**KIRKLEES METROPOLITAN COUNCIL
INVESTMENT & REGENERATION SERVICE**

Reference No: 2021/62/92000/W

Site Address: 4, Grimscar Avenue, Birkby, Huddersfield, HD2 2TU

Description: Erection of two storey side and rear extensions, dormer windows to rear and associated alterations (within a Conservation Area)

Ground Floor Layout 1.50

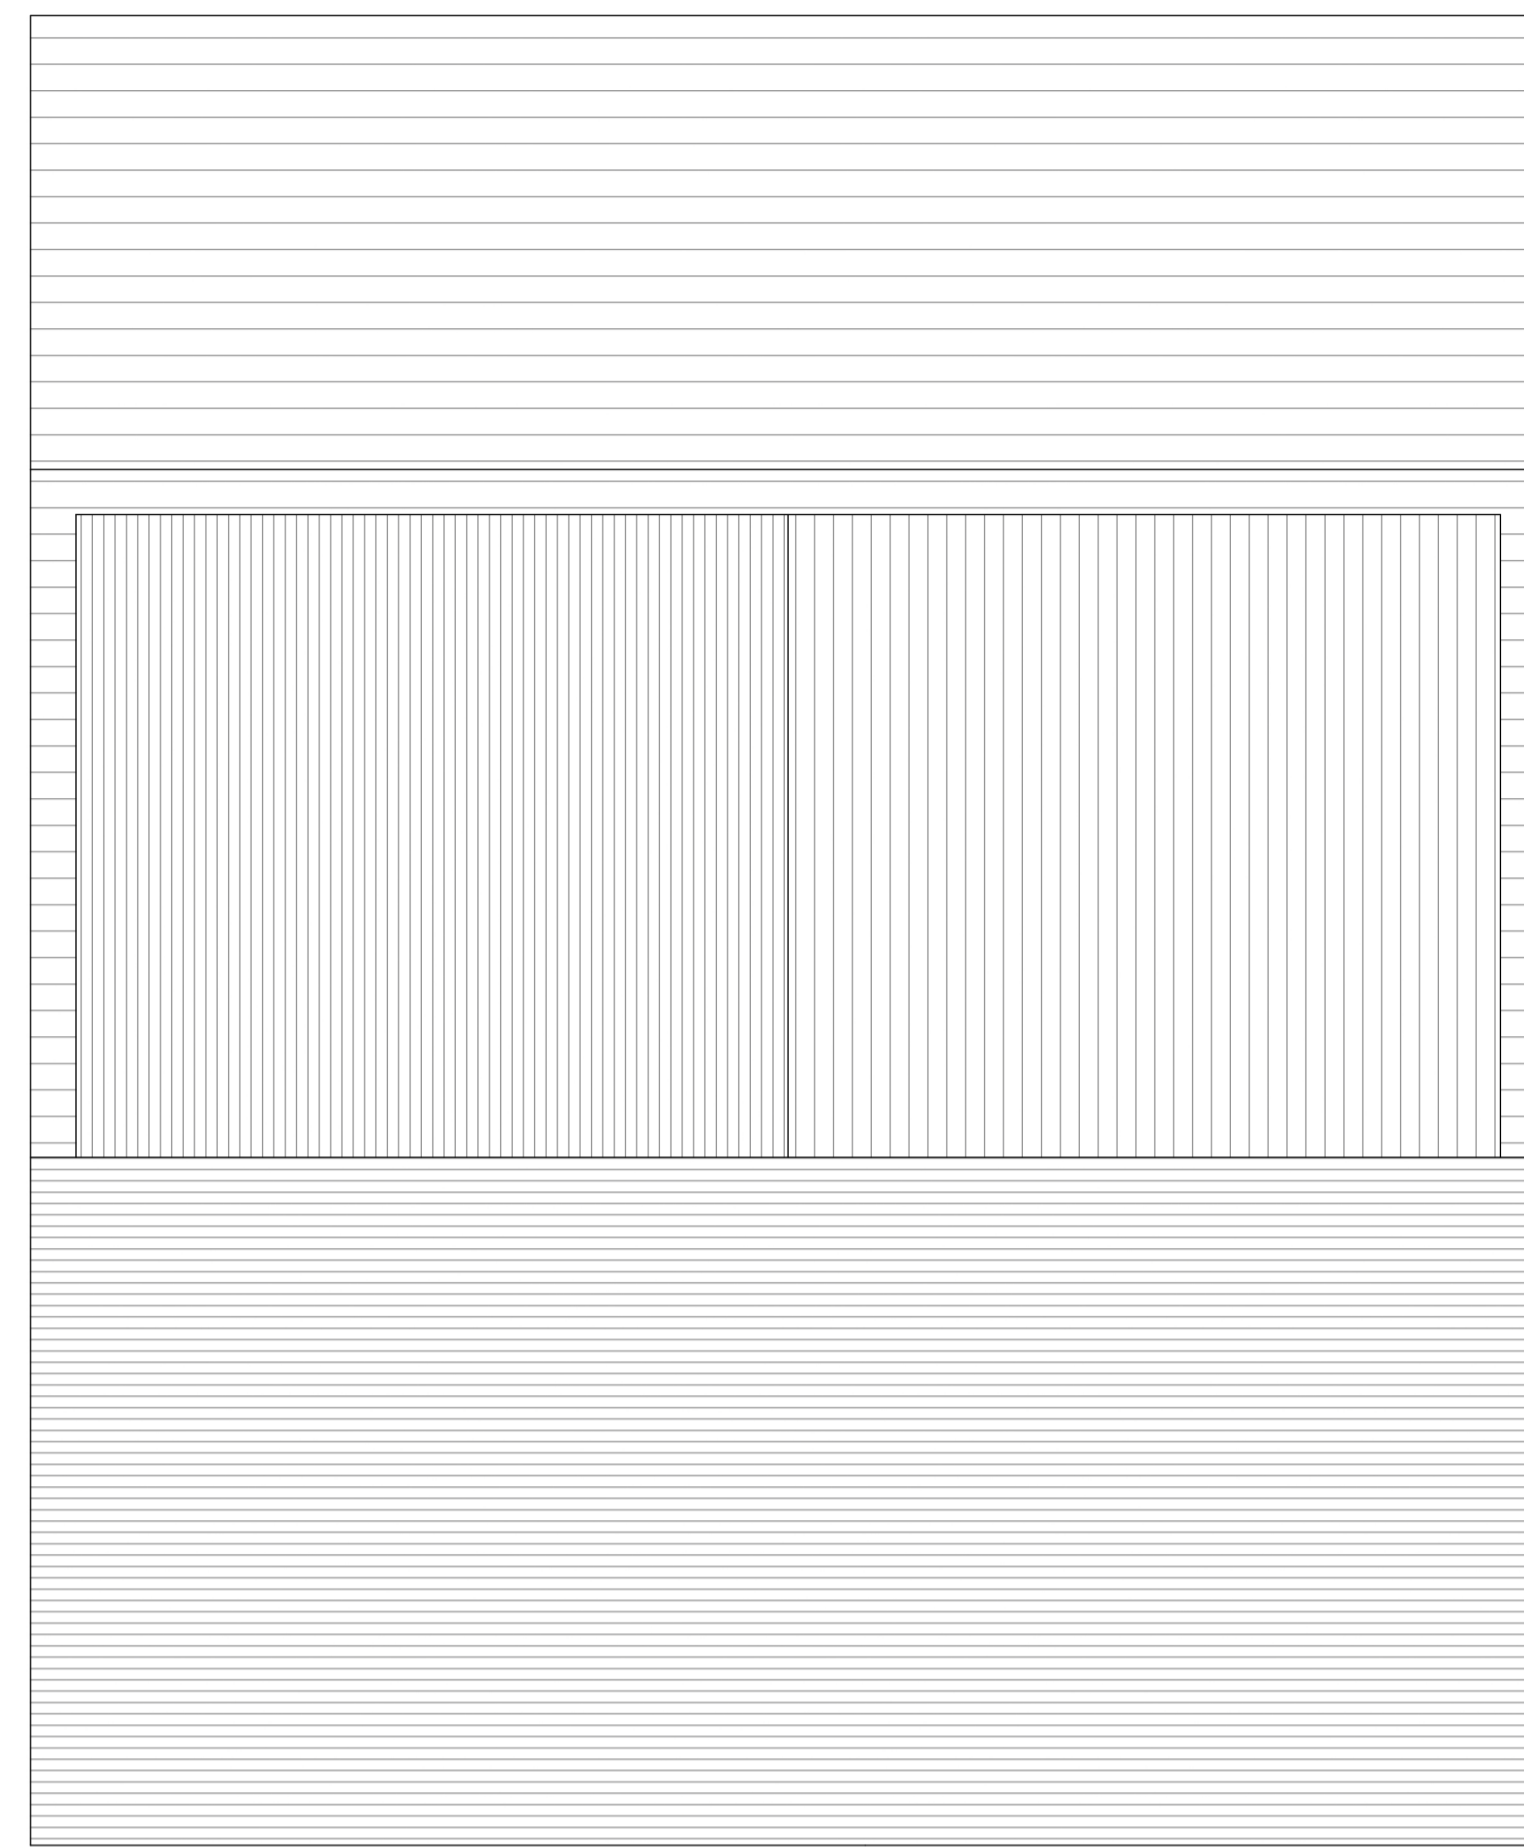
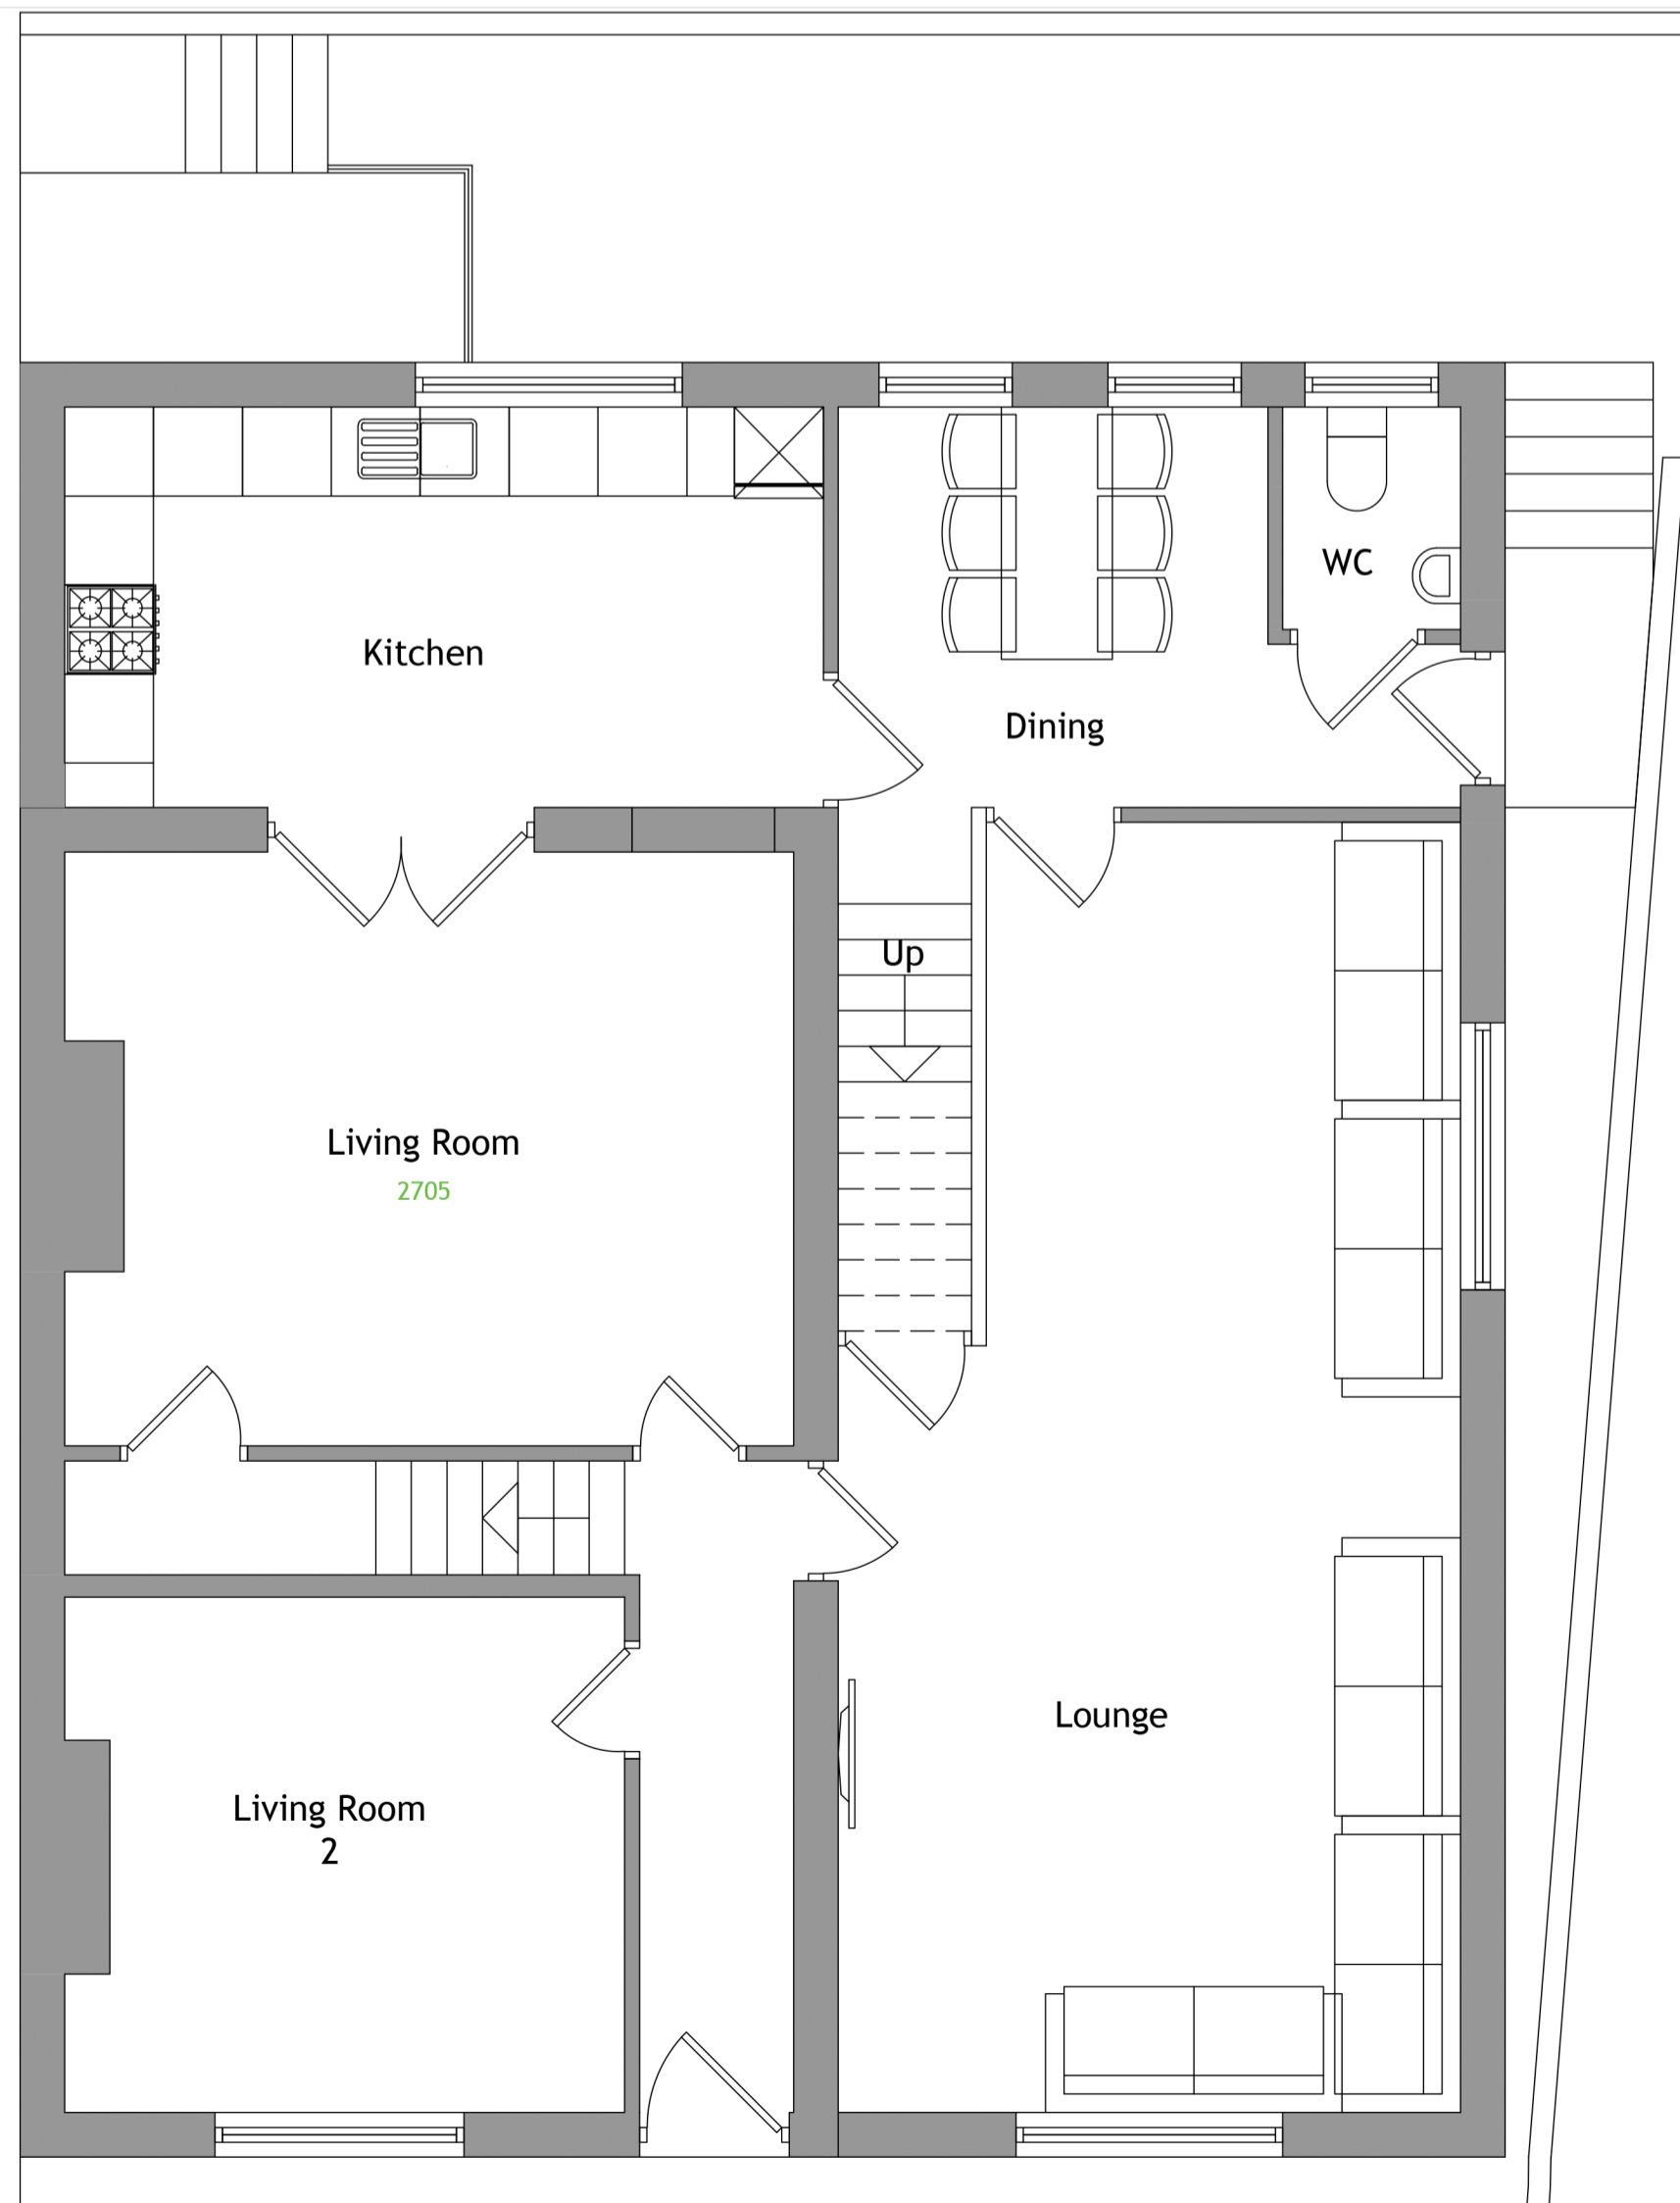
The proposal includes a 2-storey side extension which would project from the gable by 4.5m almost up to the boundary by 9.1m the depth of the host property. The side extension will be flush with the front elevation and the ridge line running through.

The proposed 2-storey rear extension would project 3m by 10m, the width of the host property and proposed side extension. The roof would have a shallow catslide, a continuation of the main roof. Given the position of the extension there will be approx. 1.4m to the rear boundary.

The proposal also includes a rear dormer in the host property and side extension, having a width of 9.4m with twin gables and the ridges in line with the host property.

The drawings indicate a basement with access from the garden and main property however no layout has been submitted for this

The proposed 'L' shaped extension would be built almost to the side boundary along Bleasdale Avenue with only a max distance to the boundary of 1m which tappers down to almost 0.1m towards the corner and front of the property. To the rear of the property the extension would be approx. 2m away from the rear boundary again this would be reduced to 1.3m due to the tapering site boundary. Resulting in no amenity space remaining for the property to the side or rear, with only the small front garden remaining untouched.
